**Re: Yennora Liquid Waste Treatment Plant (SSD-10407) – Outstanding Information**

This letter contains additional information requested in Yennora Liquid Waste Facility - SSD 10407 – based on consultation with DPIE in September, October, and November 2021.

INTERIM OVERNIGHT PARKING PLAN  
SCALE 1:100

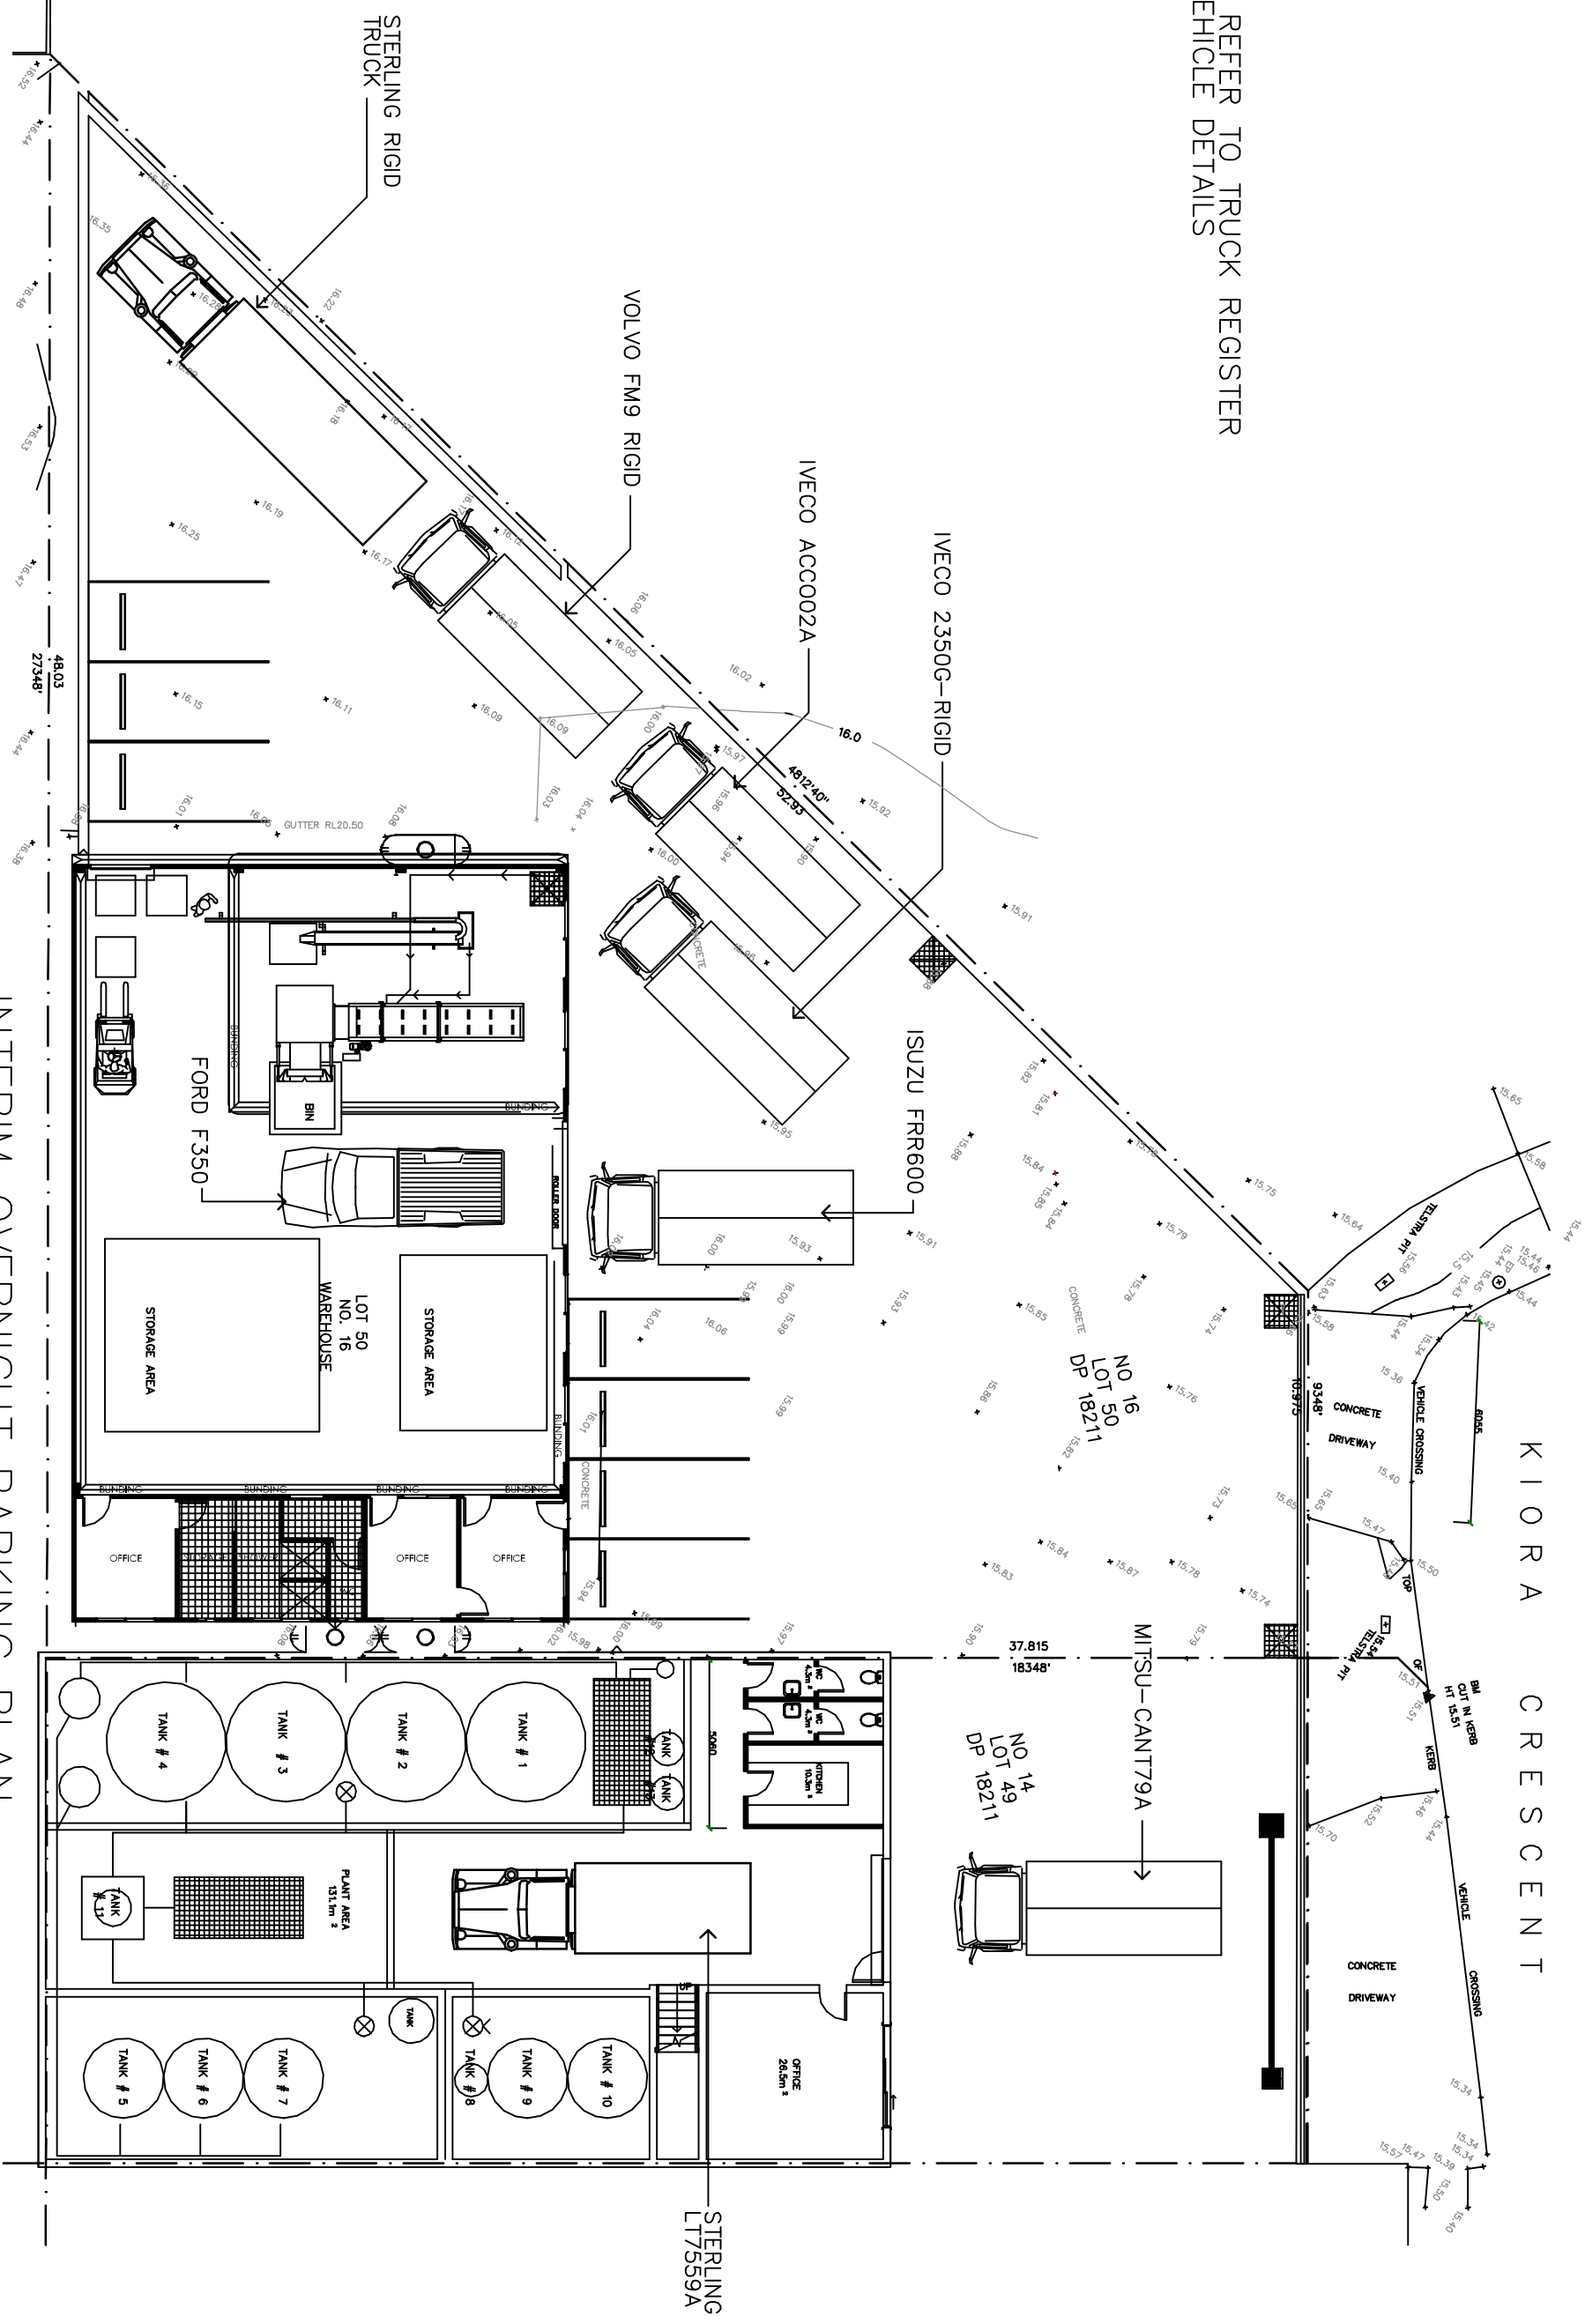
*Truck parking is currently proposed at a third-party site located at 25-49 Nelson Road which currently has approval to park trailers associated with the warehouse and distribution centre. It is noted a modification has been submitted to Council to permit trucks from this development to park at that address. Provide evidence of the modified consent which includes the storage of trucks from the proposed development.*

In the interim, as a worst-case scenario, it is possible to park all vehicles on site overnight. The site cannot operate when all vehicles are parked. This will only occur in the interim awaiting approval from 27-49 Nelson Road, Yennora. Drawings showing the parking configuration are shown Attachment 5 of this letter.

Overnight parking can be achieved across the two sites as follows:

16 Kiora Crescent:

This site can house a maximum of four (4) trucks without interfering with the site operations, or house six (6) trucks with ceased operations.

- The truck waiting area located along the western boundary can park a maximum of four (4) trucks. Any configuration of 4 trucks from the site can park in this location.  
This parking **does not** interfere with operations.  
In the Interim Overnight Parking Plan the trucks shows these trucks: Sterling Rigid truck, Volvo FM9 Rigid, IVECO ACC002A, IVECO 2350G-RIGID).
- The free area in front and inside the building can park a maximum of two (2). These parking locations do not conflict with the swept paths.  
This parking **does** interfere with operations. If used, operations at 16 Kiora will cease.  
In the Interim Overnight Parking Plan the trucks shows these trucks: Ford F350 and ISUZU FRR600
